**CHESTER HILL MATERIALS RECYCLING FACILITY (06_0052 Mod 2)
PROPERTY: Lot 8 DP 1039882, No. 191 Miller Road, CHESTER HILL**

I refer to your letter dated 16 November 2011 and apologise for the delay in providing you with a response. Your correspondence refers to an application to modify the approval issued for a Metal Recycling Facility to allow shipping containers to remain as a permanent noise reduction method instead of the previously proposed concrete walls.

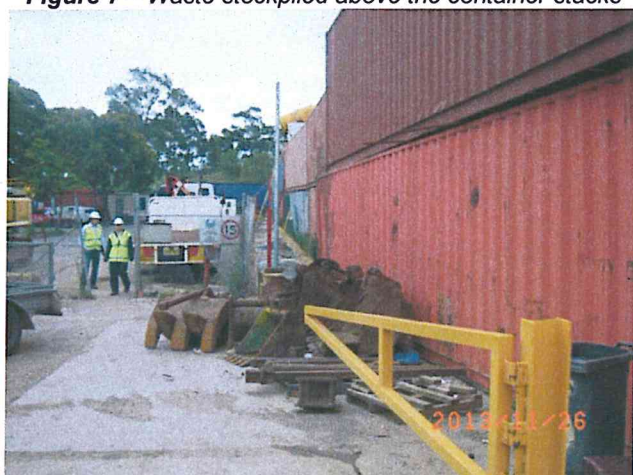
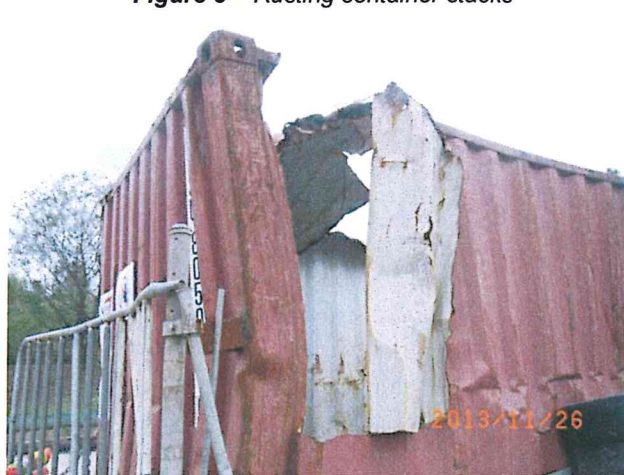
- **The visual impact of these shipping containers.**
Concern is raised as to the impact these structures will have on the visual amenity of the locality particularly the fact that over time shipping containers may rust and weather.
- **The permanency of these containers.**
Concern is raised as to the likelihood of these shipping containers remaining on site for the duration of the life of the operation. Over time these containers could be easily removed.
- **The success of the containers achieving and satisfying the necessary acoustic requirements.**
